**Minsmere Levels Stakeholders Group,
Stop Sizewell C and
Theberton and Eastbridge Parish Council
Issue Specific Hearing 6
Oral Contribution by Cllr. Paul Collins**

Coastal Geomorphology

DRAWING TITLE:
PERMANENT COASTAL DEFENCE FEATURE
TYPICAL SECTIONS (MAIN)

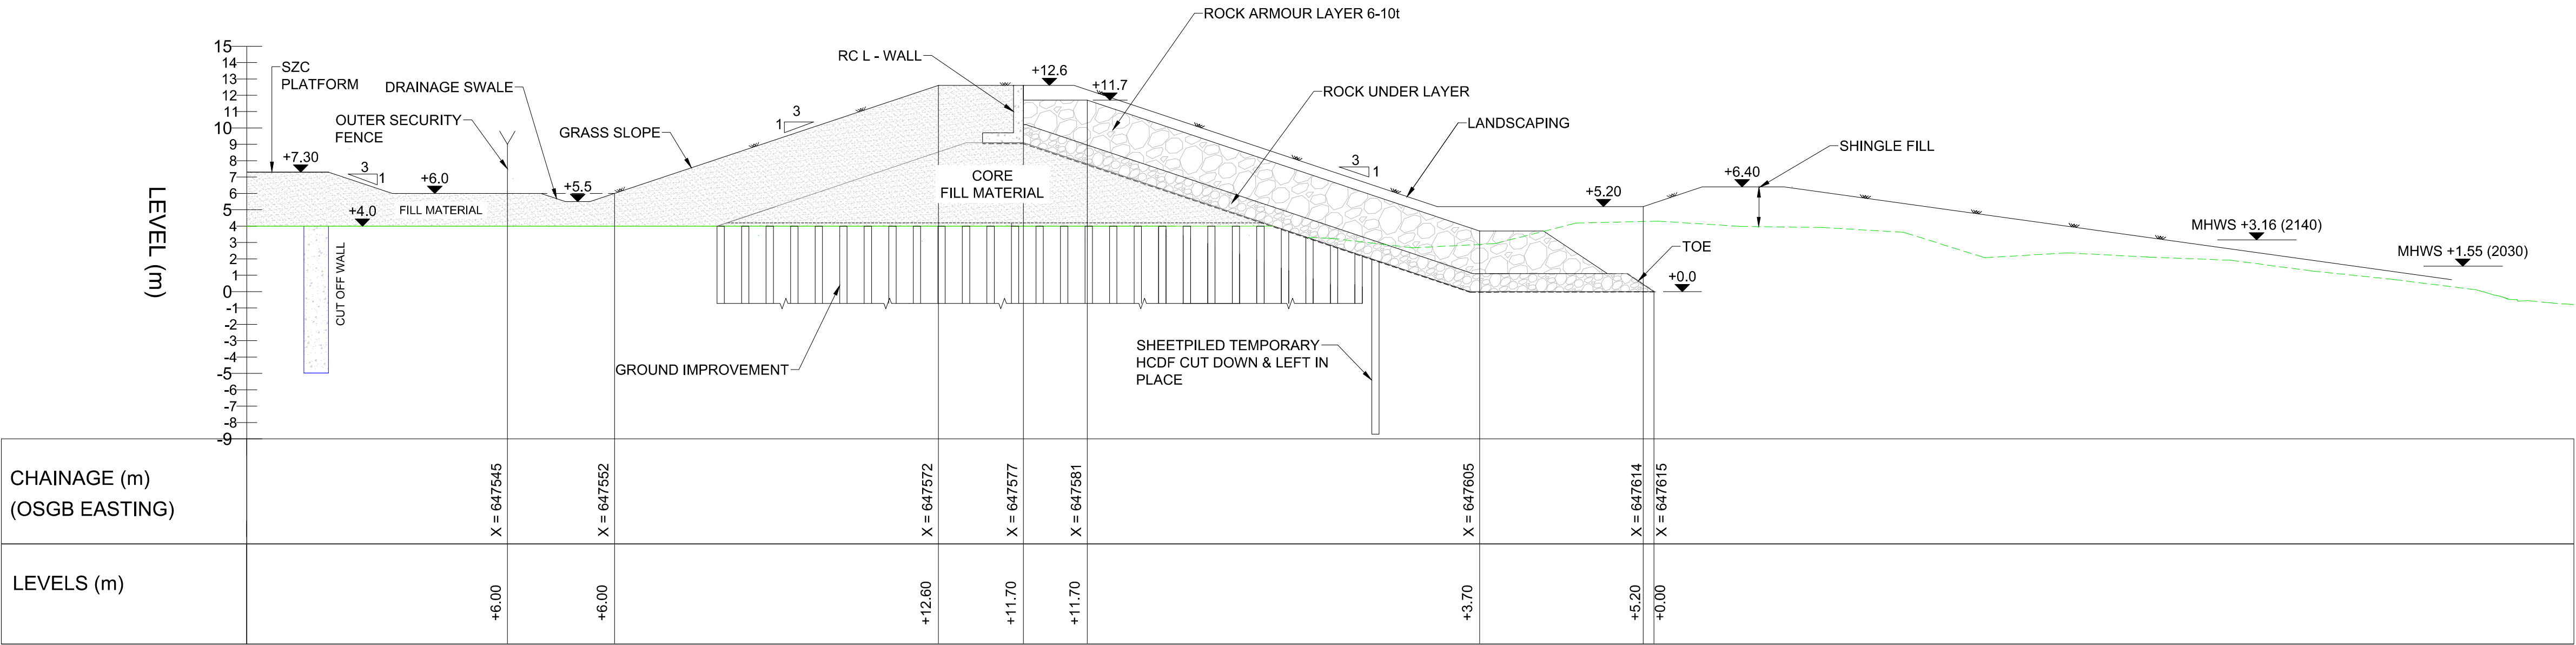
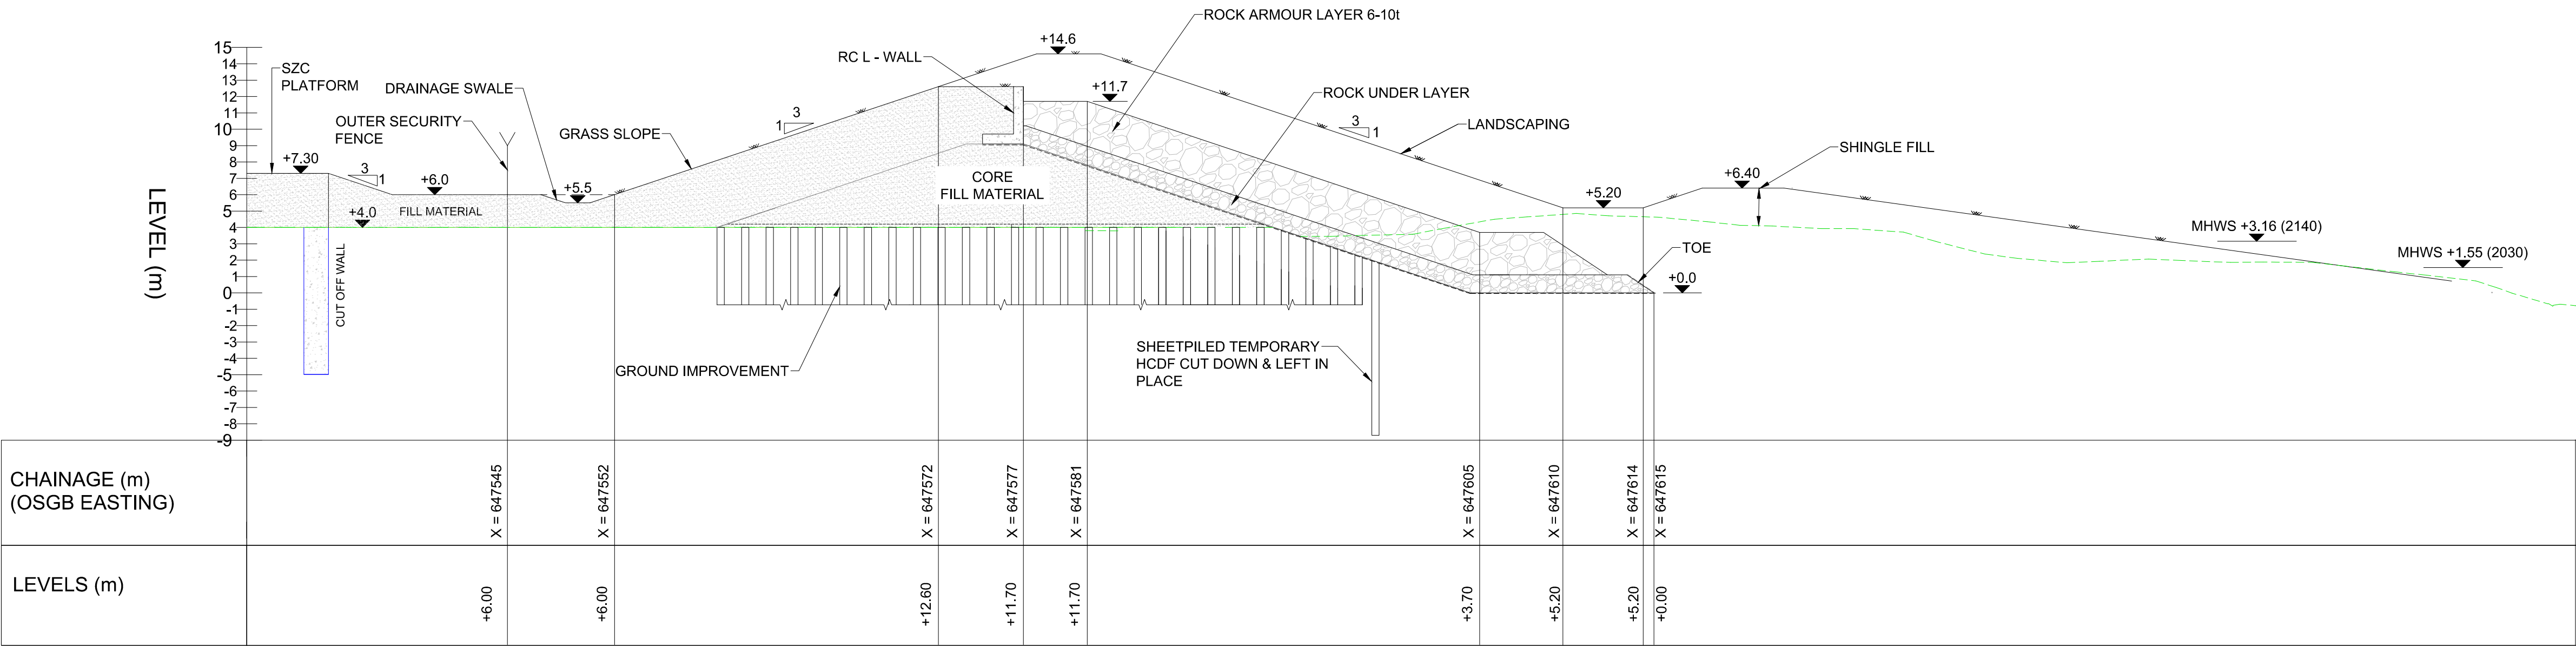
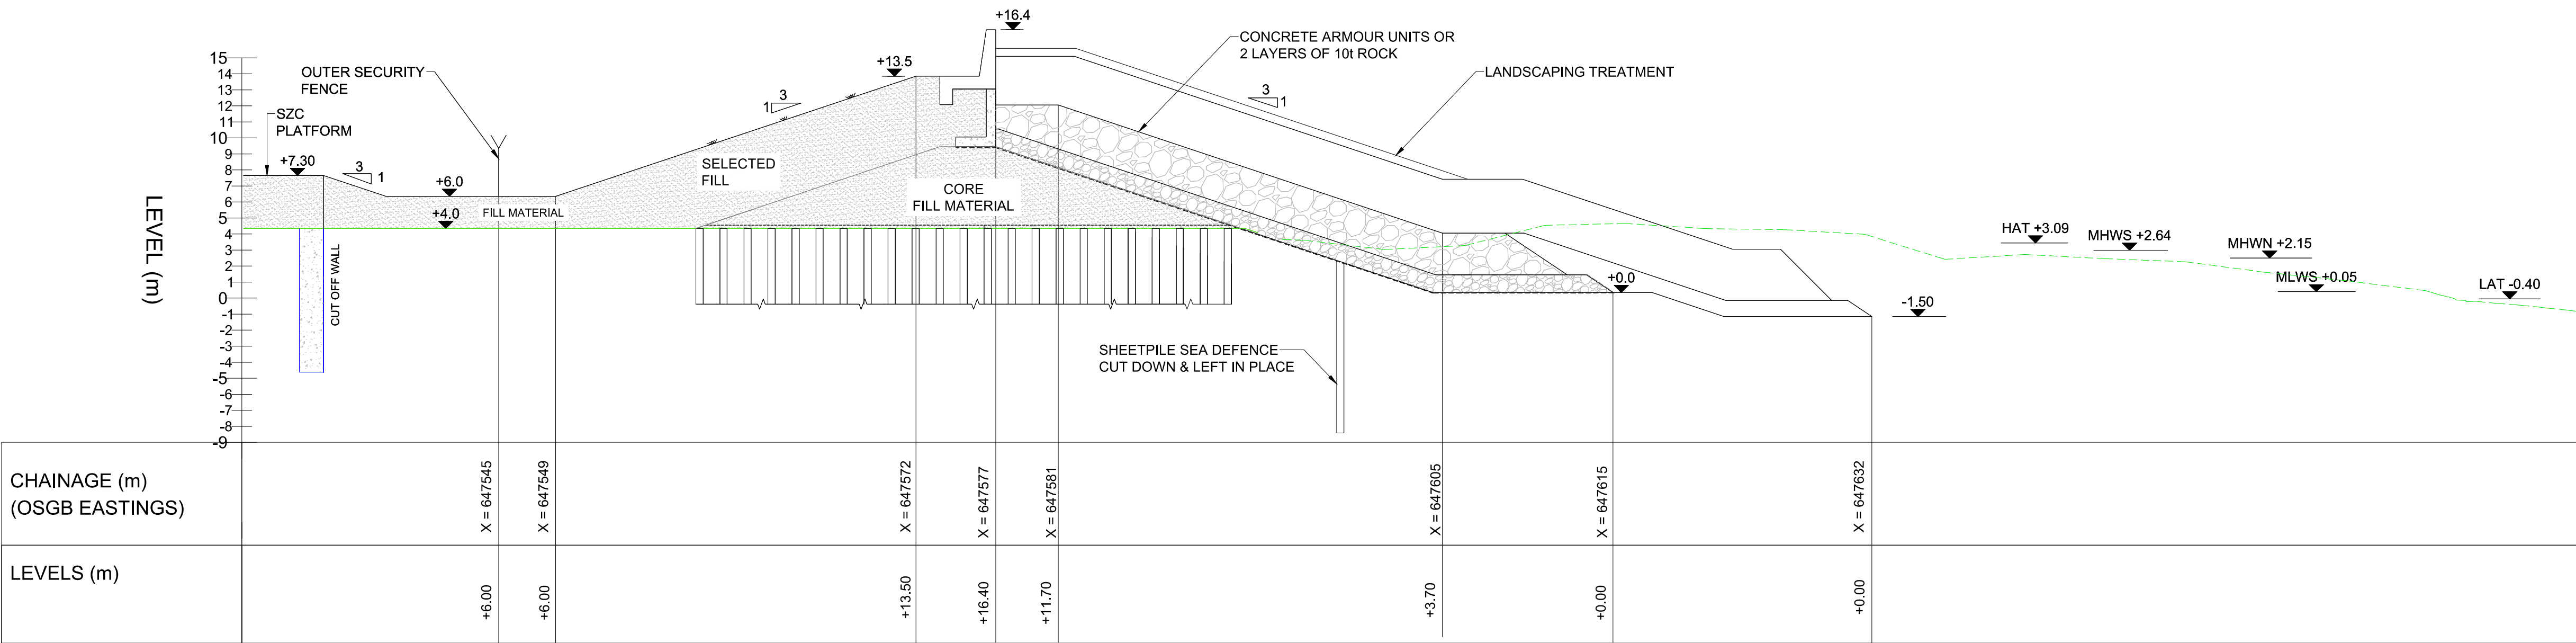
- If the hard coastal defence is removed, we end up with the cut-off wall as being the only thing that's there. I'm pretty certain that nobody intends to remove the cut-off wall because the wall is something like seven metres above ordnance datum, certainly on three sides.

- There are also references to the cut-off wall being four metres above ordnance datum on the seaward side, which would seem to me to be somewhat of a risk as far as what is left on the platform at the end of at the end of that period.

- The cut-off wall is not really something which would encourage any sort of natural process to return, should the sea come anywhere near that structure. It might be good for sitting on the edge of it and dipping your fishing rod into the into the sea to catch something, but even then, I have some concerns about that. So, I'm sort of puzzled by this requirement. That's without going into the detail of how you remove all of the ground conditioning and everything else that's below the Hard Coastal Defence.

- Just one small point, perhaps I should have said earlier was whether they're looking at funding to remove that, at whatever stage that is. If it's unable to be removed, there should be a funding strategy, which actually makes it maintainable for the period of time that it's necessary to maintain it. That doesn't seem to be in there at all, unless they're going to change the nature of that fund to actually do that. But I still go back to the point that removing it leaves you with a concrete wall. It doesn't leave you with a natural coast at all.
